**Planning Department
Transportation Development Services**

**Re: The Carlisle
3600 Central SE
Traffic Circulation Layout**
Engineer's/Architect's Stamp dated 11-11-15 (K17-D069)

Based upon the information provided in your submittal received 11-12-15, the above referenced plan cannot be approved for Building Permit until the following comments are addressed:

SHEET
C-102
4 1 OF 2

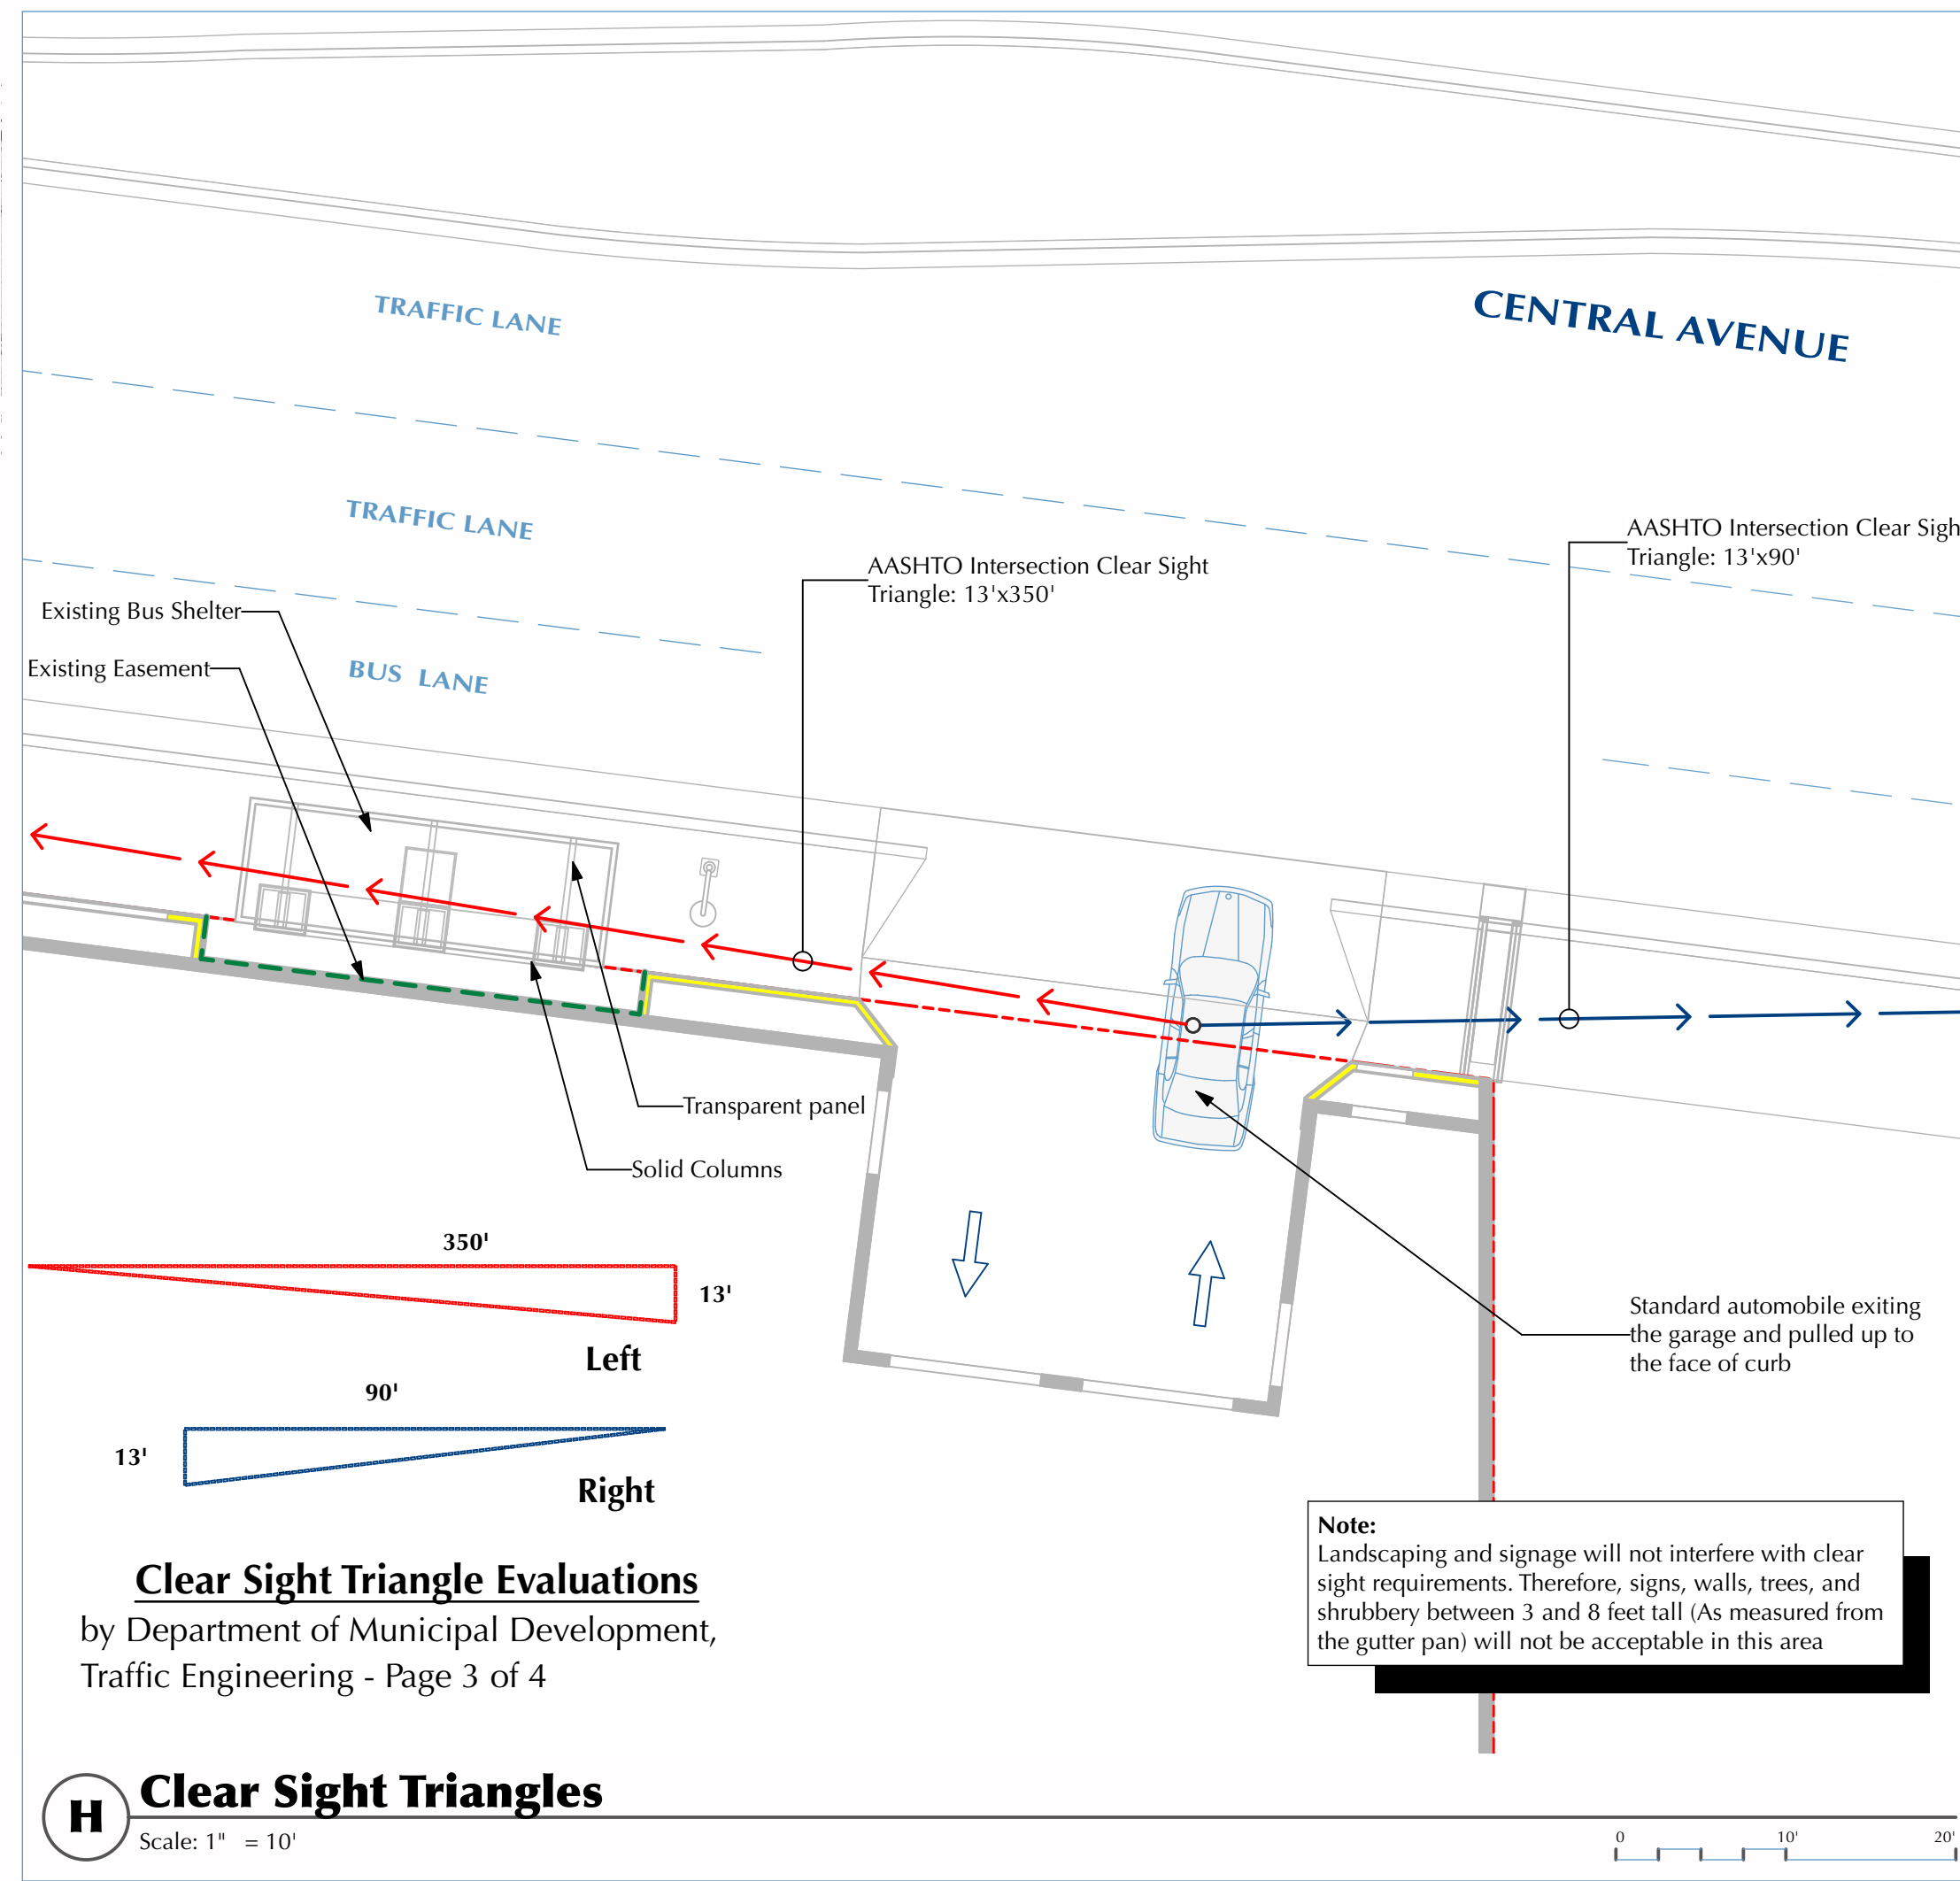
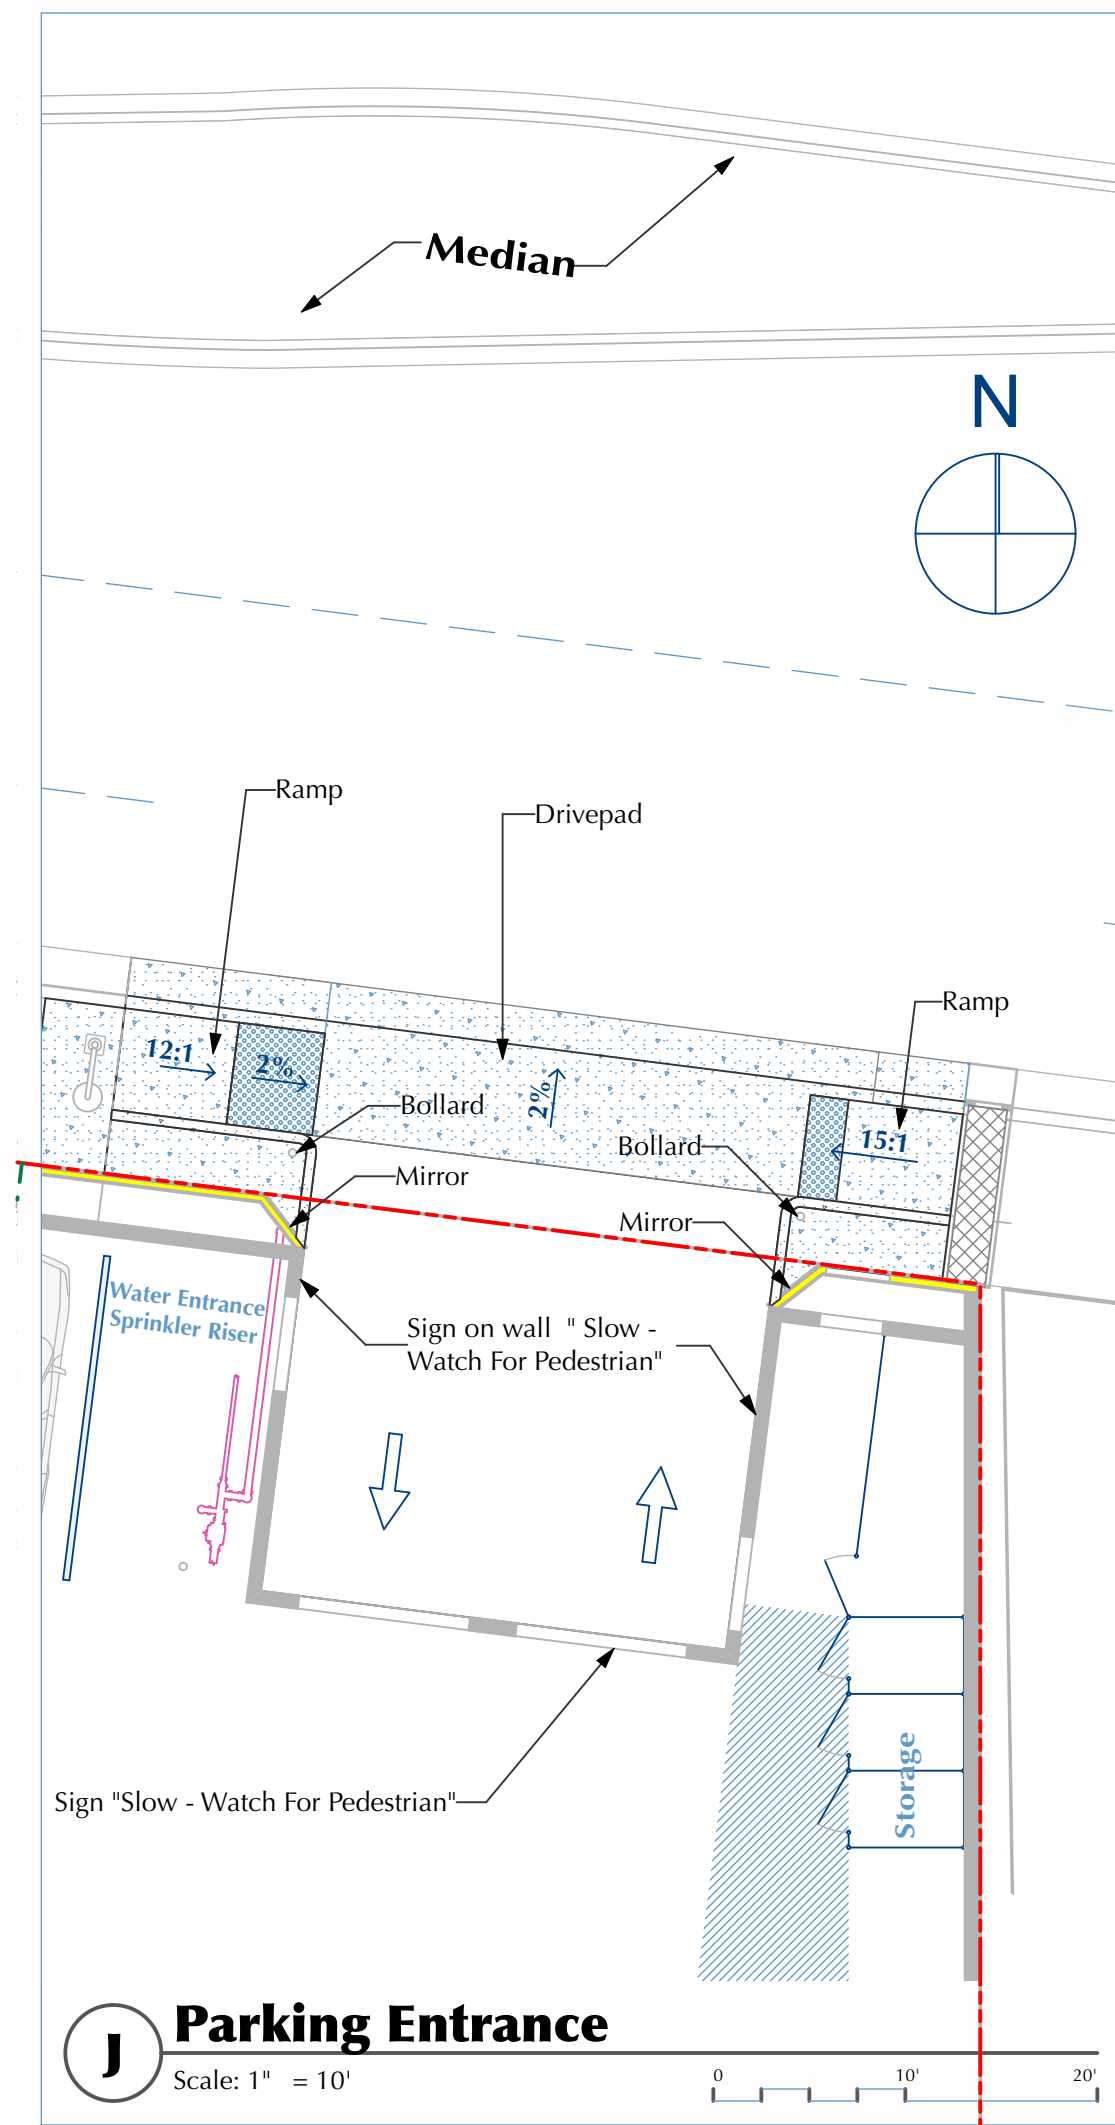
1. Upon review, the development project does not meet the Clear Sight requirements.
2. Please include two copies of the traffic circulation layout at the next submittal.
